Appeal Decision

Appeal Ref: APP/R5510/D/21/3285199

1 Blisworth Close , Hayes, UB4 9RF

- The appeal is made under section 78 of the Town and Country Planning Act 1990 against a refusal to grant [outline] planning permission.
 - The appeal is made by Mr Moshe Lipschutz against the decision of London Borough of Hillingdon.
 - The application Ref 51798/APP/2021/1795, dated 4 May 2021, was refused by notice dated 29 July 2021.
 - The development proposed is Part retrospective / part proposed erection of single storey side extension and extension of existing boundary fence.
-

ADDRESS: 1 BLISWORTH CLOSE,
HAYES, UB4 9RF
TITLE: PROPOSED DRAWINGS
ELEVATIONS
PROJECT No 434 | Date: 2021-04-28
NAME: **P 03**

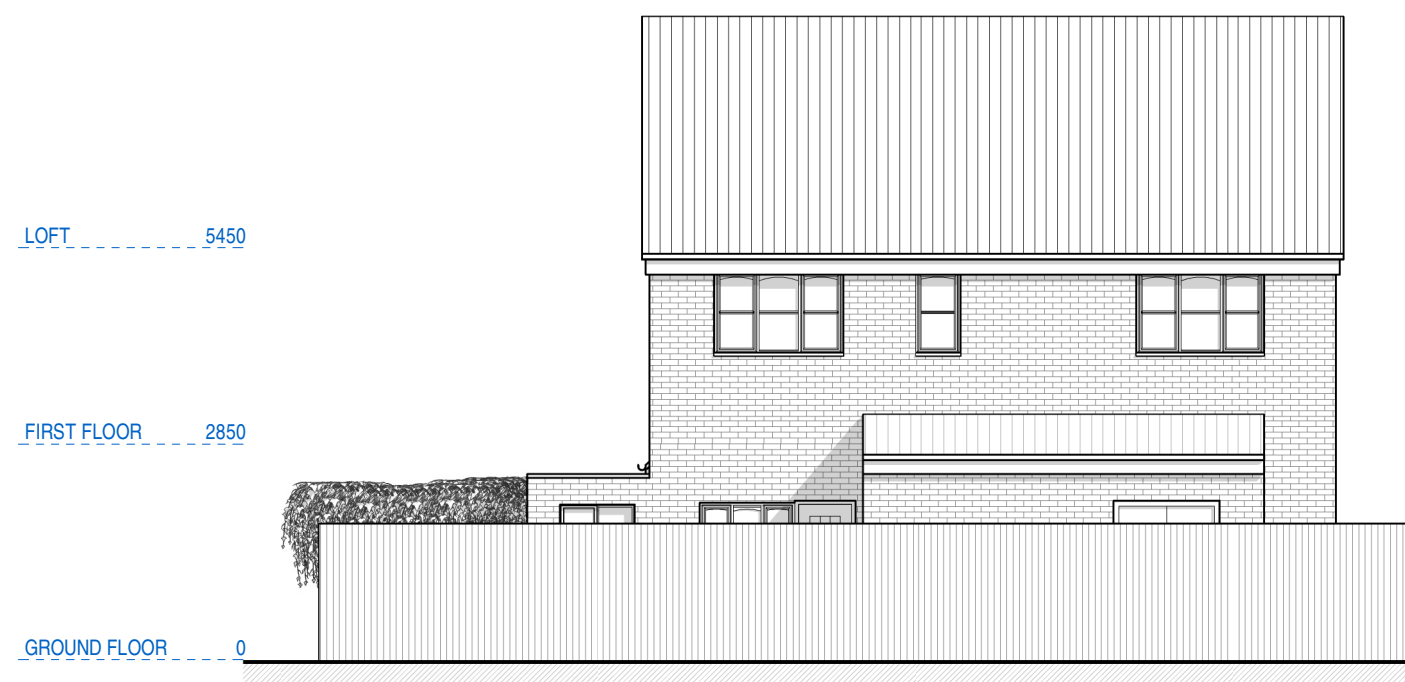
6. The spur road of Blisworth Close may be limited in width as an estate spur road, although there is a footpath that runs along the western side of the Close into it. Combined with the location of houses and their set back behind and orientation, as well as the set back of the houses on the eastern side, and the open plan nature of the estate, creates a sense of openness to the housing estate. In addition, the proposal would be flat roofed and substantially screened by the proposed fencing. Its limited scale and massing would be in proportion to the host dwelling. The extension is low level and the finished facing materials of the extension appear as an acceptable match to the host dwelling.

PROPOSED FRONT VIEW

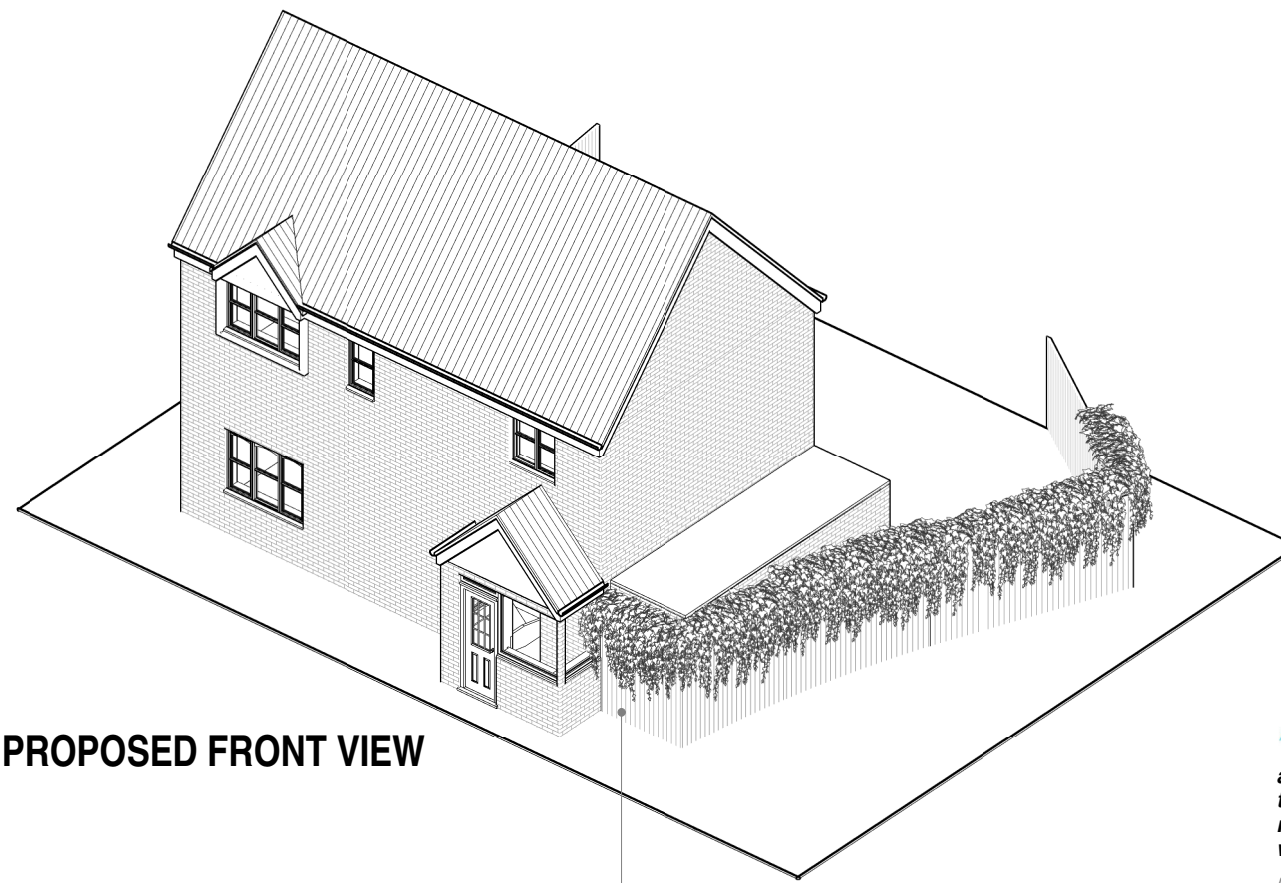
8. The proposed fence would return towards the projecting porch, but would not come forward of this element. It would not look out of character in this position in an estate where this type of enclosure is visibly present. Whilst some soft landscaping has been removed as a result of the proposal, I could see that other corners contain no landscaping features and boundary treatments. The extent of lost landscaping would not be detrimental to the local area.
